Application No: LU/315/21/PL

Site Address: 12 Cornwall Road Littlehampton BN17 6EE

Description of works: Change of use from (C3) Dwelling house to 7 bed House in Multiple Occupation (Sui Generis) including the demolition of the existing garage and erection of single storey side extension (resubmission following LU/240/21/PL). This site is in CIL Zone 4 and is CIL Liable as a House in Multiple Occupation.

Thank you for your internet representation made on 16th December 2021 which has been recorded as an objection with the comments as follows:

Drawing No 2350-P-01	Revision ~
-------------------------	---------------

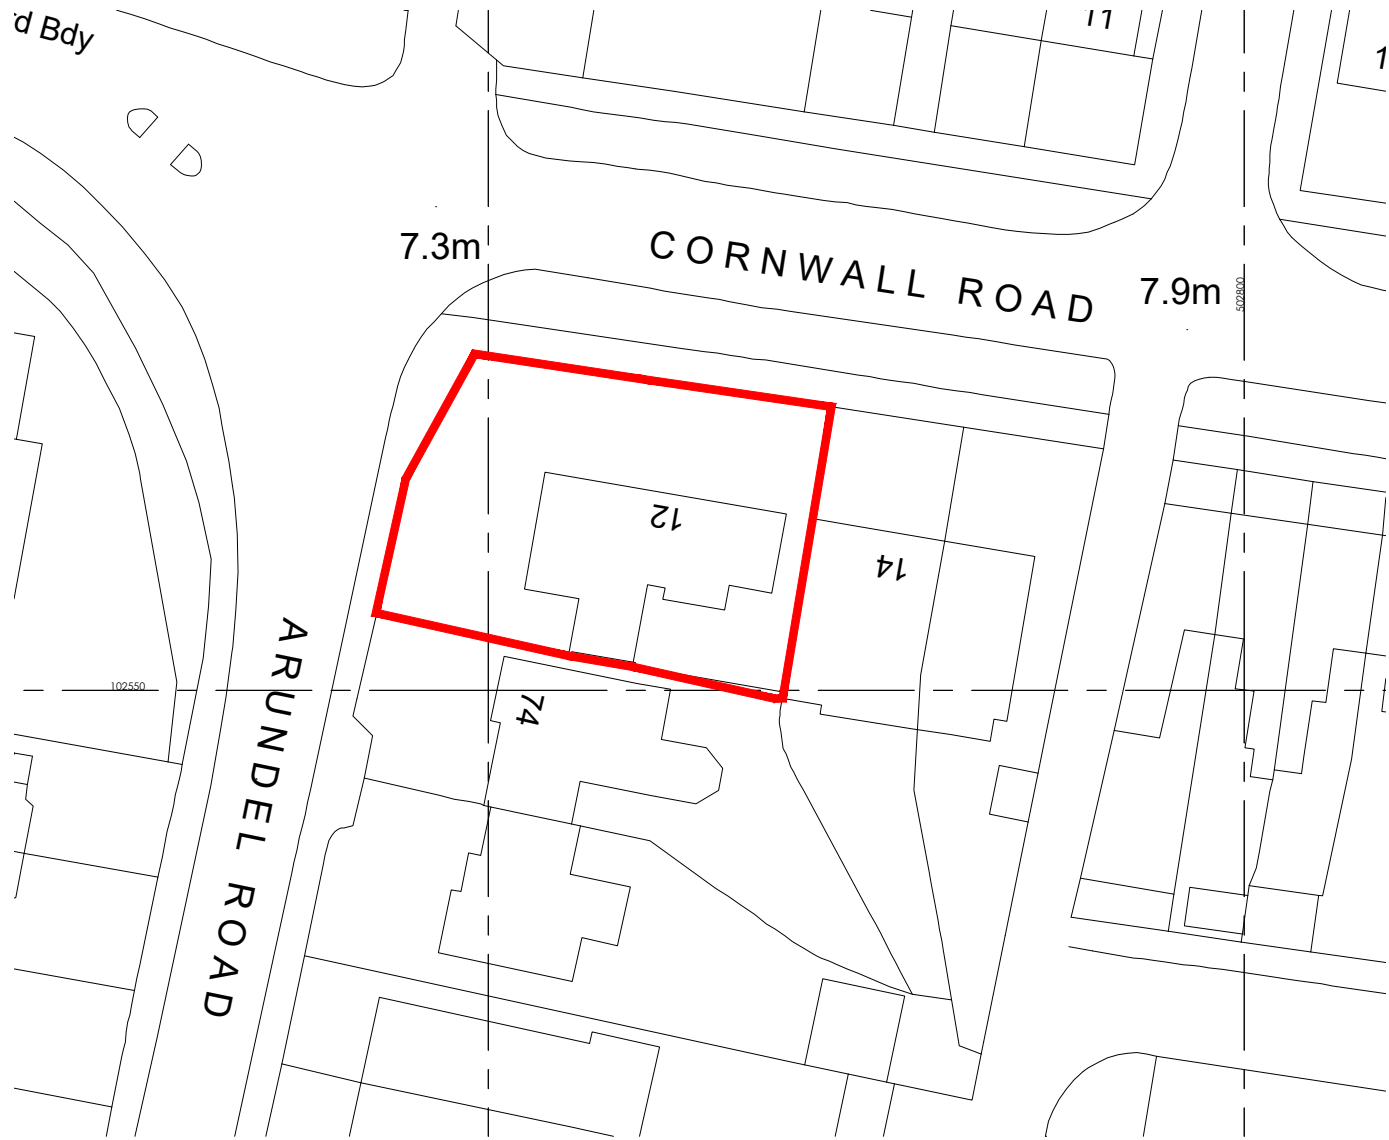
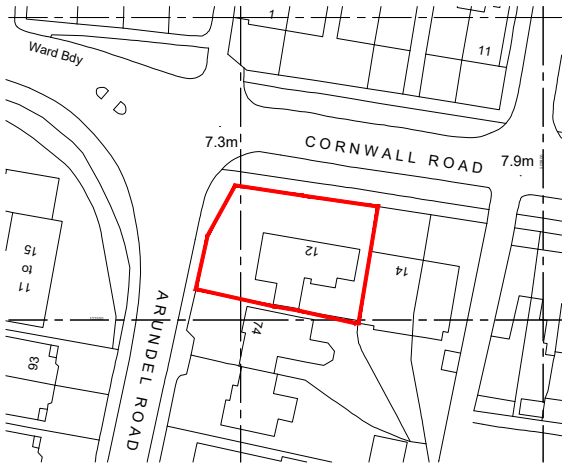
The plans for parking are not a true representation and have been drawn in by hand which anyone could do ,there is no mention of size or turning arc of vehicle for proposed parking and the red line cuts the corner of the building
